From: Paul Cann
Sent: 07 March 2018 15:58
To: Planning.Responses
Subject: RE: Planning Consultation on WA/19/18/DOC

Condition no.8 Surface Water Drainage

Site Address: Deans Yard Orchard Way Fontwell BN18 0SJ

Description of Works: Application for approval of details reserved by condition imposed under planning permission WA/27/15/PL (Appeal reference APP/C3810/W/15/3132744) relating to condition No. 4 (Schedule of materials), 5 (Contamination risks) & 8 (Surface water drainage scheme)

Surface Water Drainage Plan

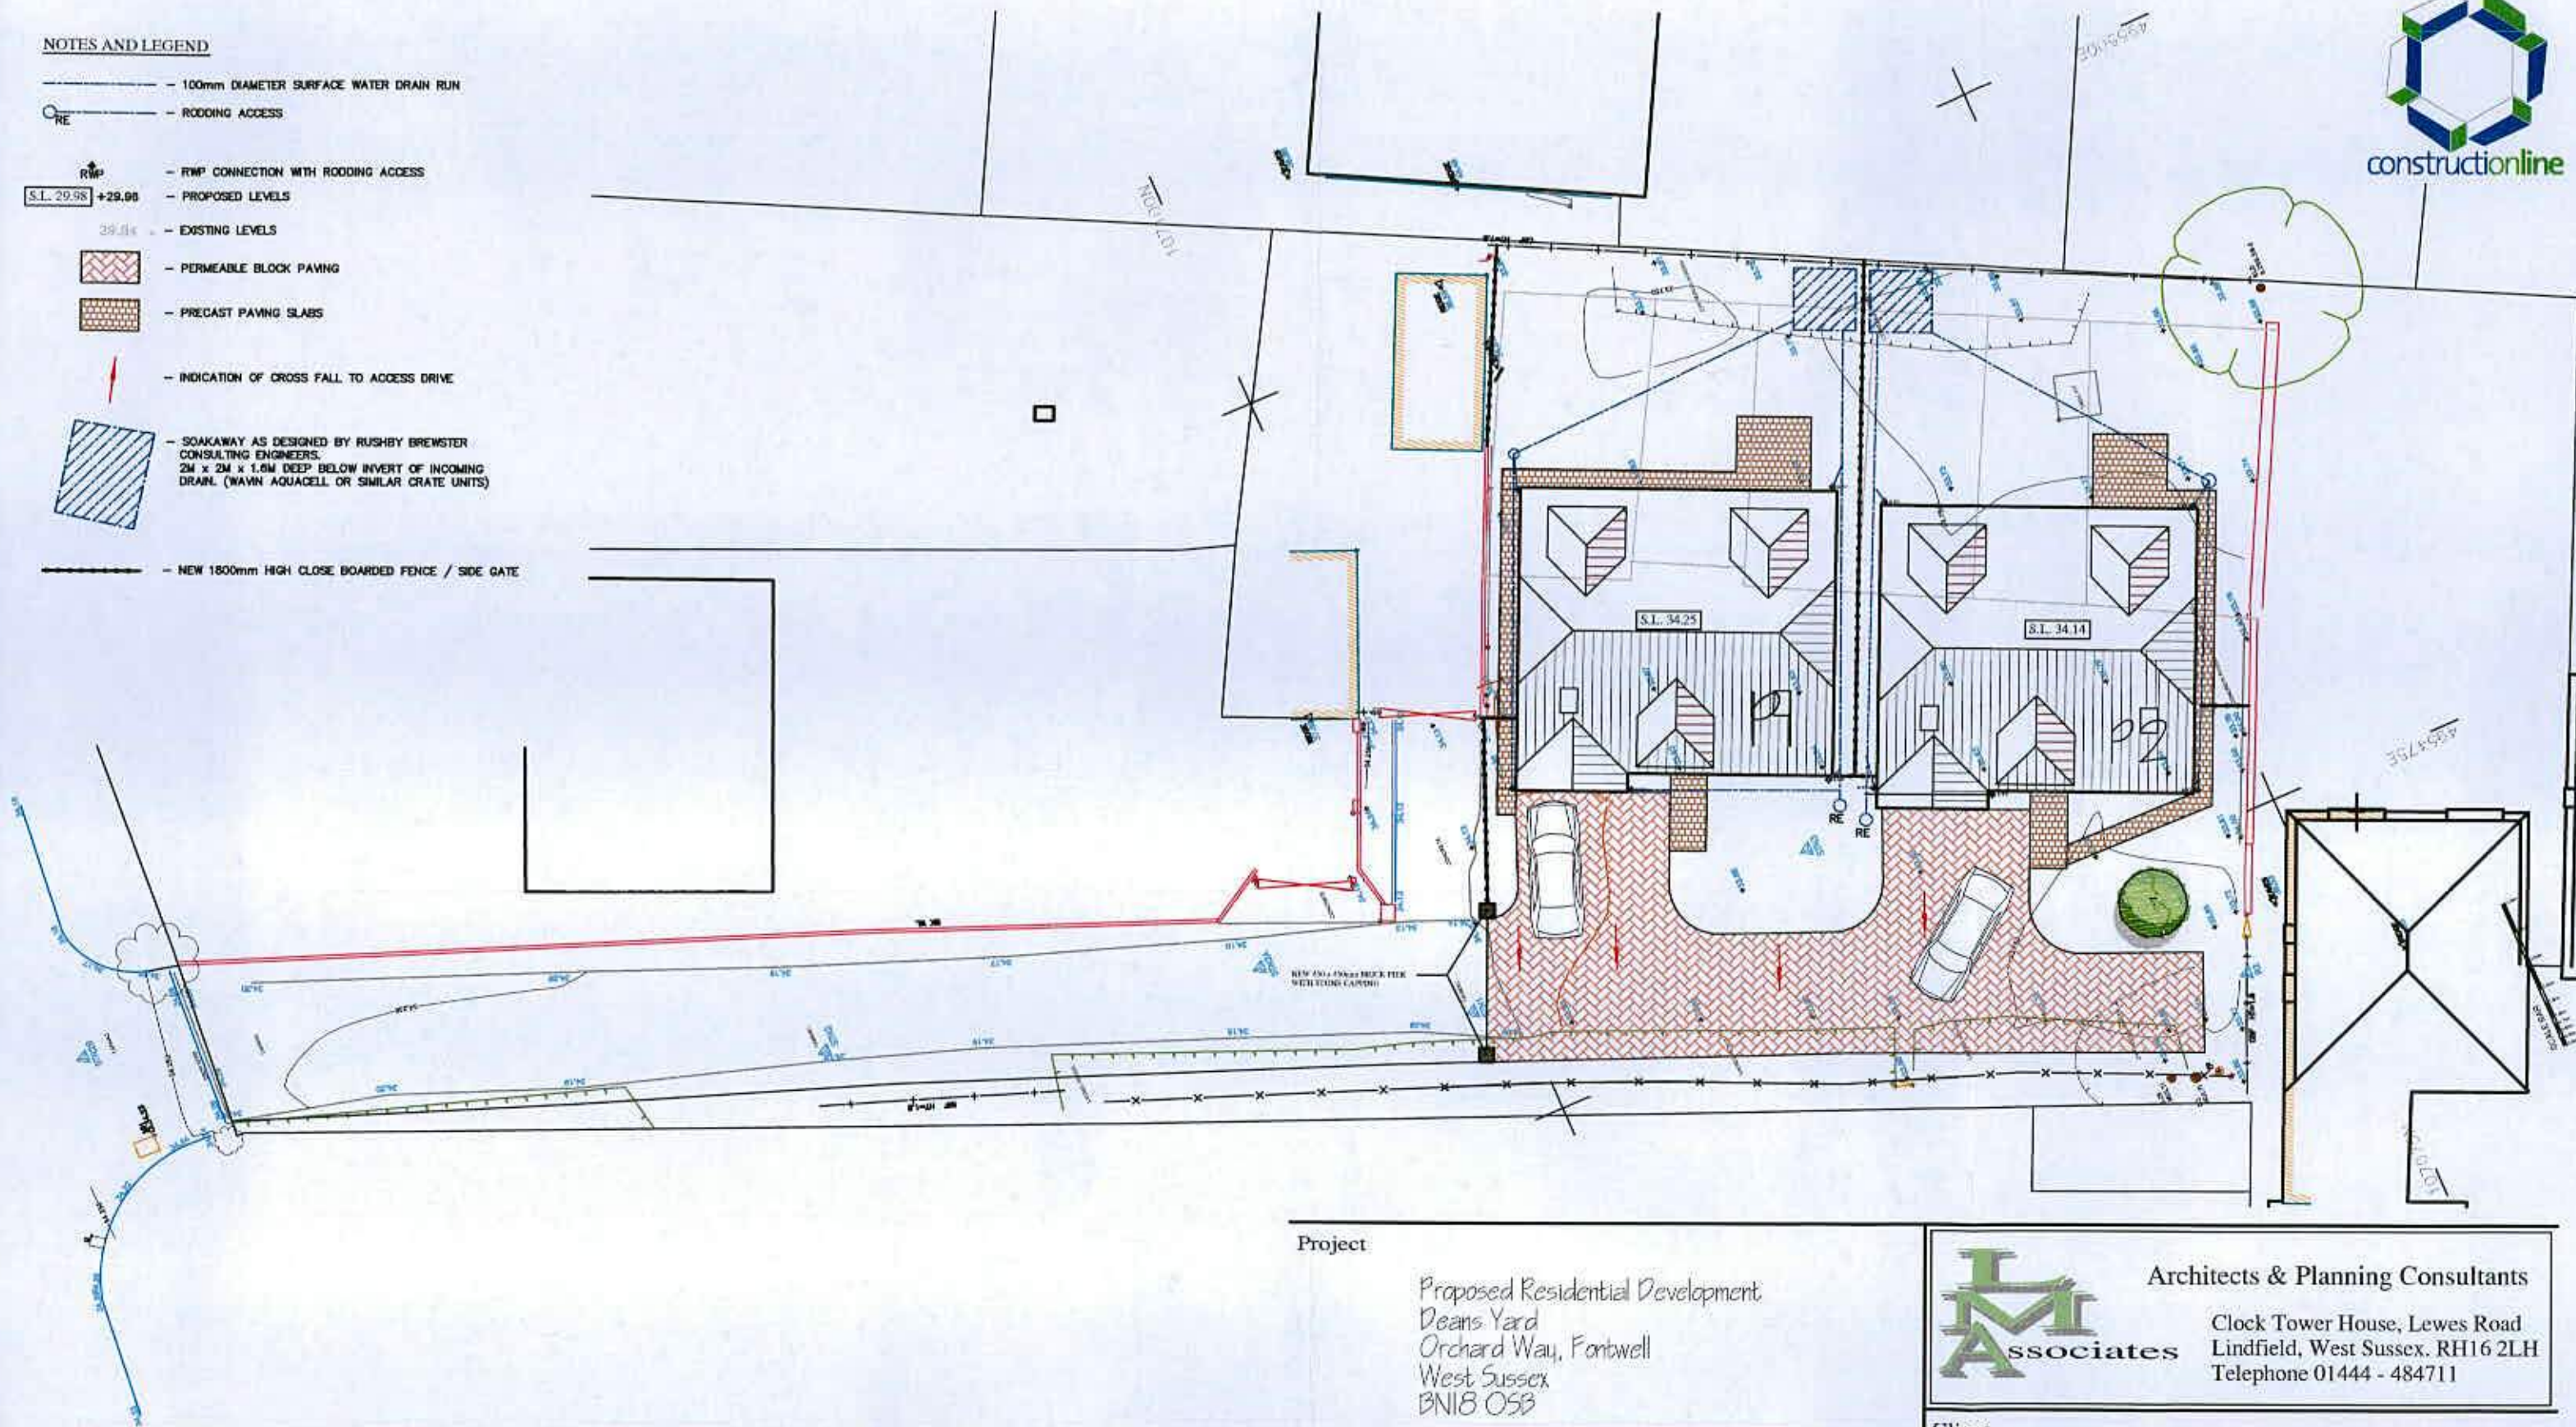
2. The scanned copy of the layout drawing is very poor, so levels are not readable. Please supply a better copy.
3. Storage calculations – will also need to be provided for the permeable pavement and all calculations need to include 30% allowance for climate change.

4. Full construction details will be required for the permeable pavement and crate soakaways.
5. Silt trap manholes to be provided upstream of the crate soakaways. Specify on plan and provide construction details.

6. The two soakaways are too close together and this will affect their performance. Please adjust.
7. Pipe gradients/invert levels/soakaway base levels/cover levels/finished surface levels will all need to be provided.

8. Please confirm if the existing driveway it to be reconstructed.
